An
Bord
Pleanála

Inspector's Report 319531-24.

The Dean Hotel 80, 82, 84, 86
Bohermore Galway City

S5.3.24

Image 1: Extract from Dwg S5.02 "Existing Third Floor Plan" prepared by Lawrence & Long Architects, with the subject small increases in gross floor area shaded blue.

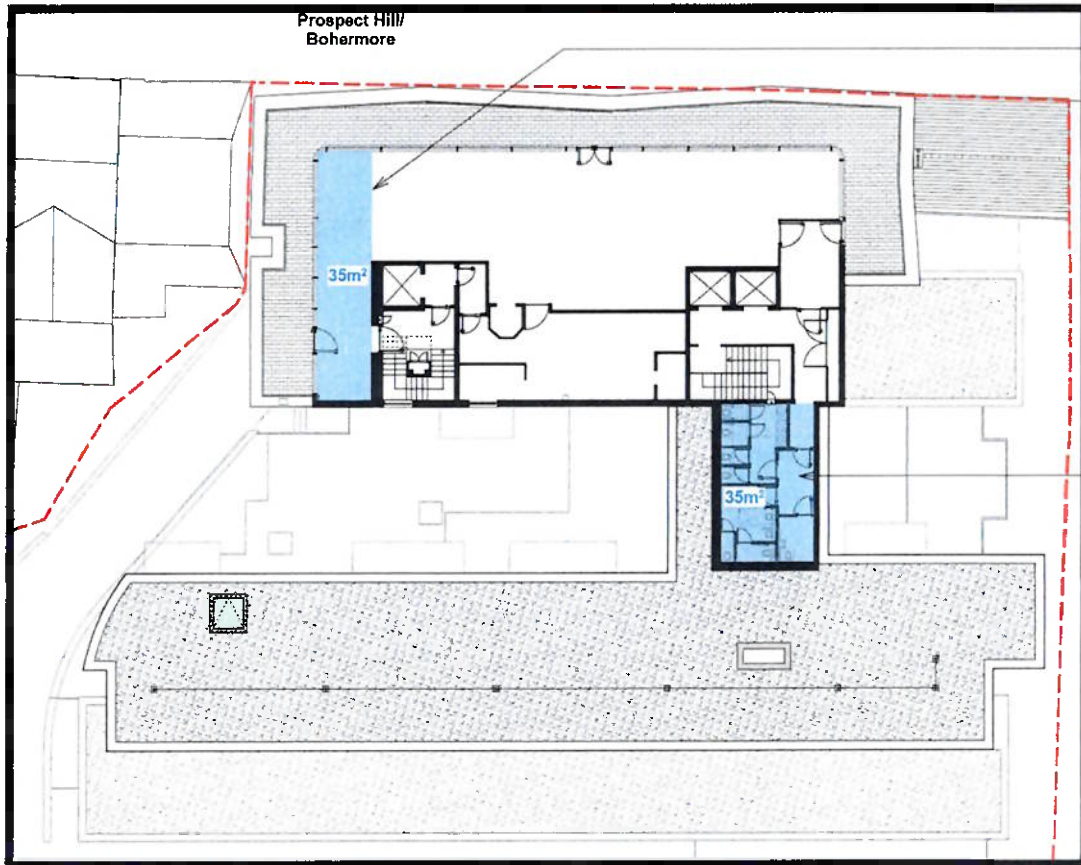
Having reviewed the site history and parent permission for the hotel under planning reference 17/41, I note that from a comparison from the “as submitted” and “as built” drawings a restaurant has been developed in lieu of 9 no. bedrooms, with consequential changes to a flat roof which is now a screened terrace (rather than a rooftop bar). This has resulted in an increase to the floor area at 3rd floor level, in that the area of the restaurant is bigger than the area of the permitted bedrooms and the area containing the toilets was not included in the original permitted drawings.

- The increase in floor area at third-floor level totals 70 sqm and includes the addition of a WC.
- The increase in floor area at first-floor level totals 101 sqm.
- The referrer claims that the overall increase in floor area between the "as granted" and "as built" development results in only a 1 sqm net floor area difference for the entire hotel.

8.3.9 There is insufficient explanation provided to substantiate how a total increase of 171 sqm in gross floor area translates into a negligible nett difference of 1 sqm. In contrast, the submitted drawings clearly illustrate the locations and extents of the additional floor areas. While there is no statutory definition of *de minimis* in the context of planning, I consider the increases in floor areas to be significant and not minor in relation to the permitted development under the original planning application (Ref: 17/41).

Image 2: Extract from Dwg S5.01 "Existing Lower Ground Floor Plan" prepared by Lawrence & Long Architects, with the subject small increases in gross floor area shaded blue.

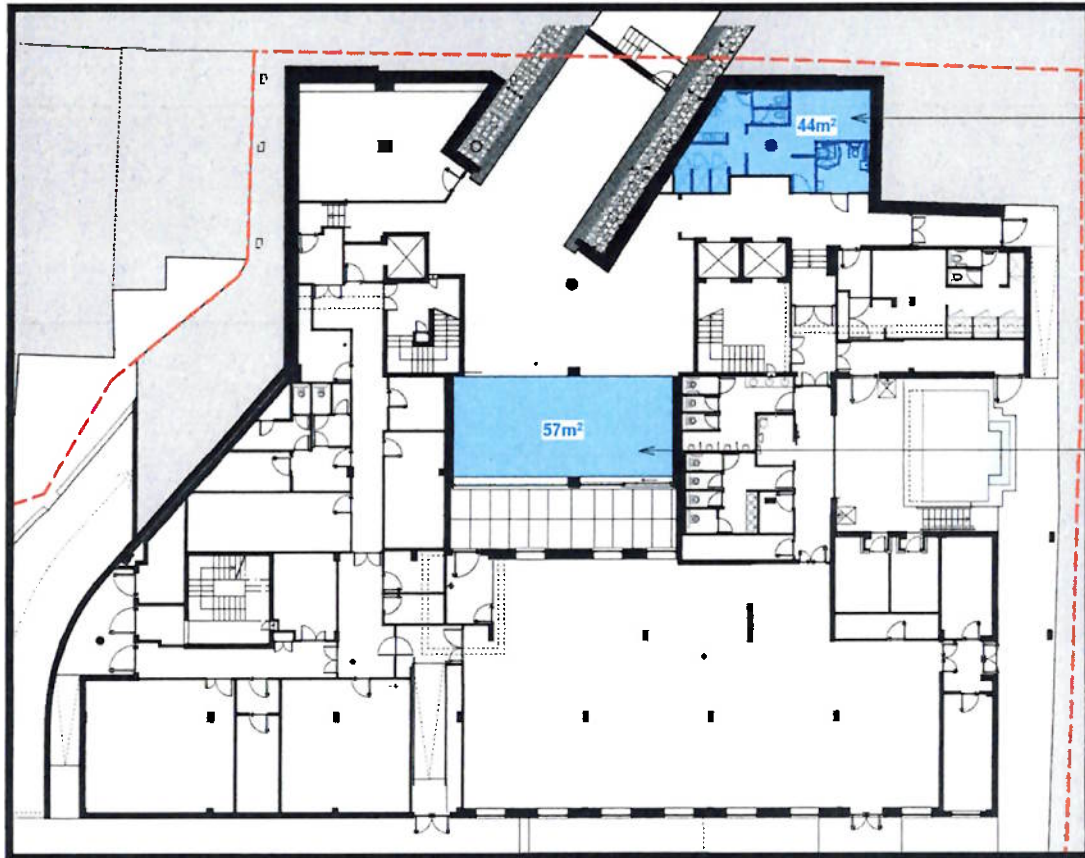
At ground floor level the area containing the gent's changing room was not initially in the permitted drawings. The gym has increased into the area permitted as Interior courtyard 1. The total area of increase in floor level as per the drawings is 101sqm. The area of the extensions took over an internal courtyard and rear yard area. The third-floor area (which includes the area of revised location of the bar and restaurant) has an increase in floor area of 70sqm. The restaurant has been developed in lieu of 9 no bedrooms, with consequential changes to a flat roof which is now a screened terrace (rather than a rooftop bar) This includes an additional area for WC. The planning authority concluded that these extensions were material as they contravened Condition 1 of parent permission 17/41.

Extract from Drawing No. P-3-R-202 (3rd Floor Plan) approved under Pl. Ref. 17/41. Submitted for Further Information on 04/07/2017. Bedrooms only at this level. Notes added by Fergus Daly on 03/11/2023.

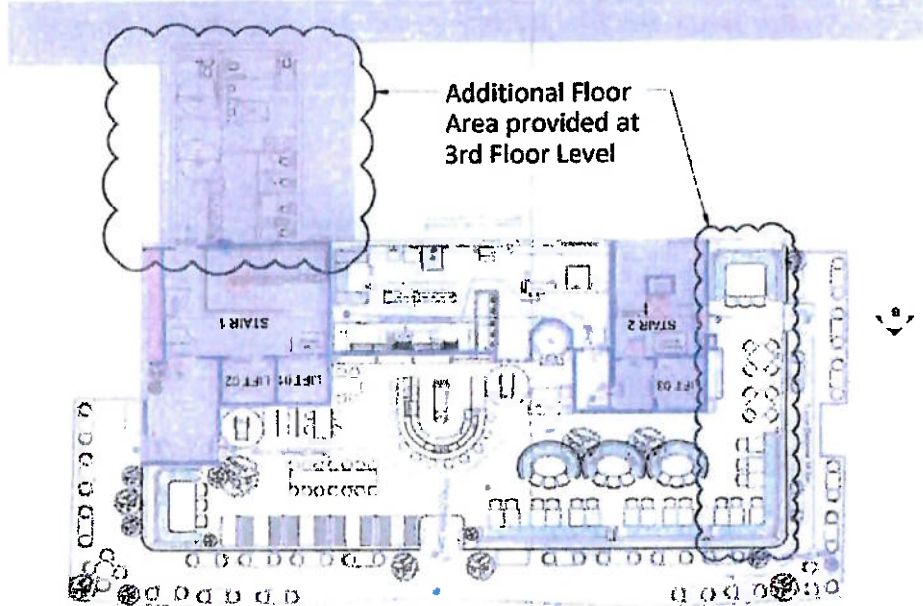
In my view, the relocation of the restaurant and bar constitutes a material change from the permitted development and is not exempted development. Regarding the materiality of changes, the courts have clarified in *Monaghan County Council v Brogan* [1987] IR 333 that the term "material" in planning terms refers to whether the changes raise issues that would typically be considered by a planning authority in a planning application. These issues include residential amenity, traffic safety, and compliance with statutory plans. While the referrer asserts that there is no material impact on residential amenity due to the revised restaurant and bar location, such considerations are inherently planning matters and require evaluation under a standard Section 34 planning application.
